Consultation Response from: KC Environmental Health (Pollution & Noise Control)
2022/93518 3 Knowler Hill, Hightown, Liversedge, WF15 6PH
Erection of detached dwelling, formation of vehicular access and parking areas, and demolition of existing detached garage
**Responding Date:
29th November 2022**
**Responding Officer:
SR**
**Responding Ref:
WK202238299**
Comments

We have reviewed application 2022/93518 and make the following comments and recommendations.

Drawing Title
PROPOSED

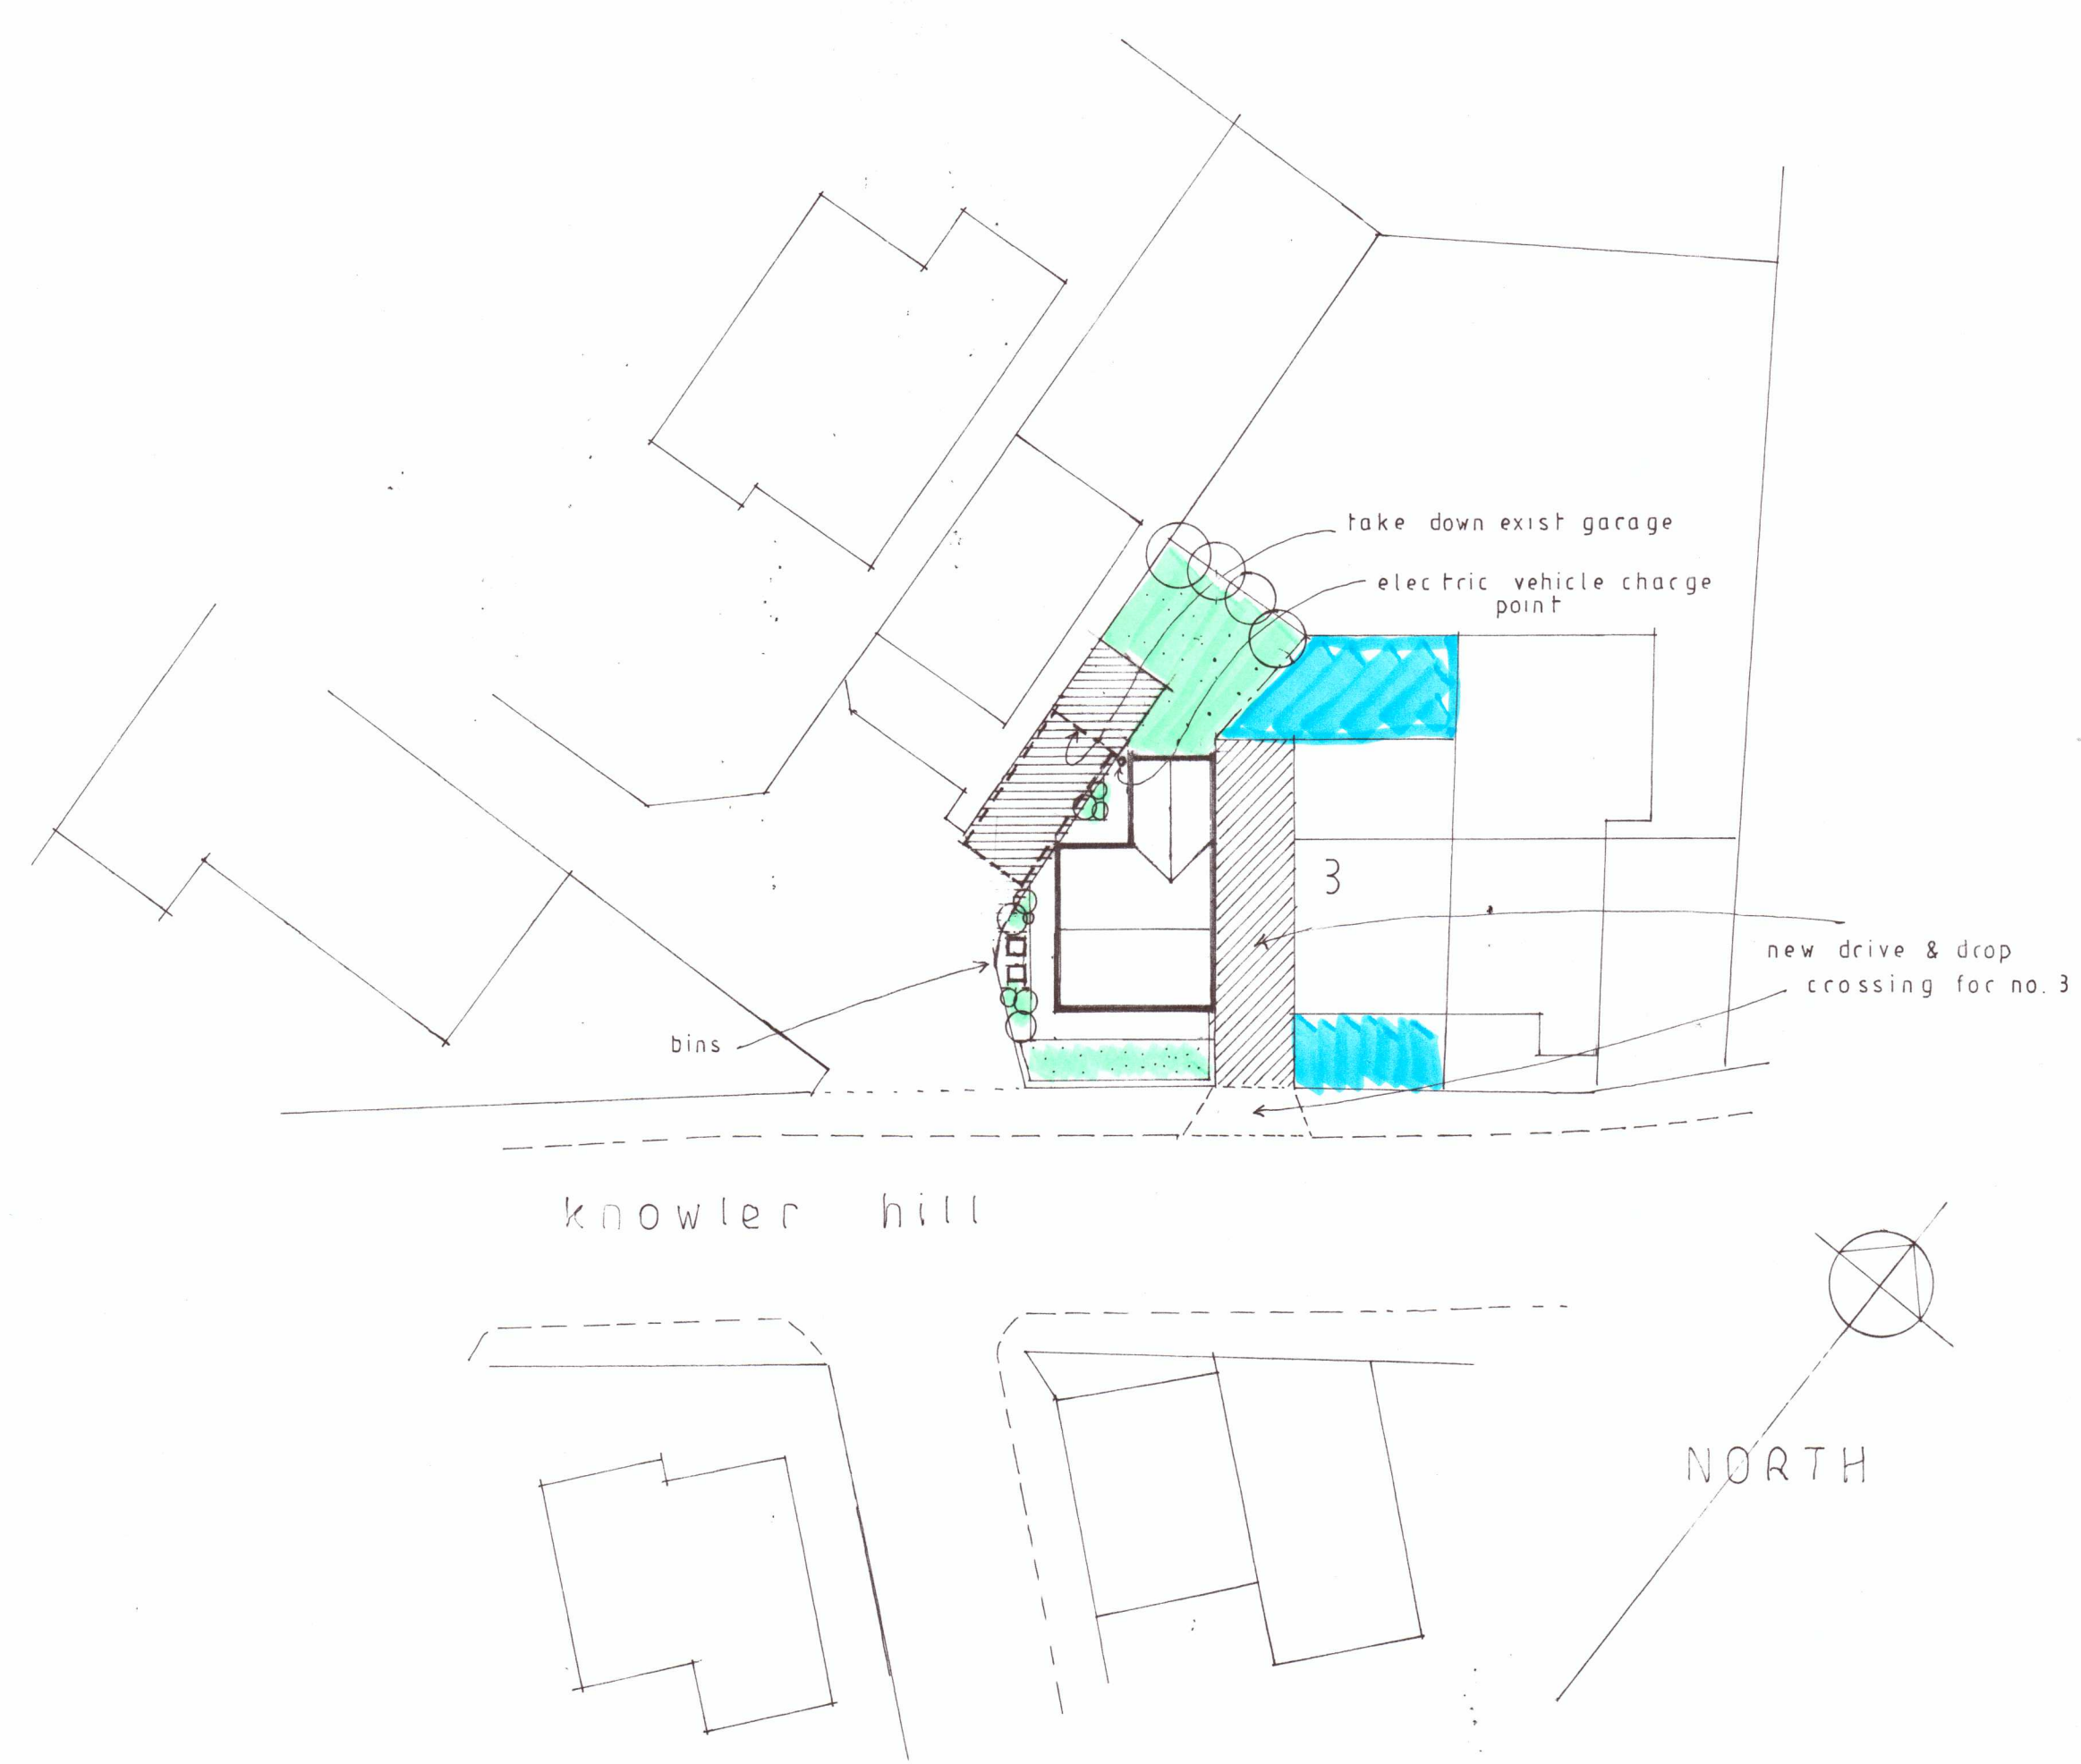
The plan titled Proposed, dated October 2022, drawing number 22/146 shows the location of an Electric Vehicle Charging point, it does not specify the details of the unit to be installed. In an application of this nature, it is expected that facilities for charging electric vehicles and other ultra-low emission vehicles are provided in accordance with the National Planning Policy Framework and *Air Quality & Emissions Technical Planning Guidance* from the West Yorkshire Low Emissions Strategy Group. A condition requiring charging points is therefore necessary.

Before the electrical system is installed a scheme detailing the dedicated facilities that will be provided for charging electric vehicles and other ultra-low emission vehicles shall be submitted to and approved in writing by the Local Planning Authority. The scheme shall meet at least the following minimum standard for numbers and power output:

- A Standard Electric Vehicle Charging point providing a continuous supply of at least 16A (3.5kW) for each residential unit that has a dedicated parking space

The approved dedicated facilities for charging electric vehicles shall be installed prior to occupation and retained for use thereafter.
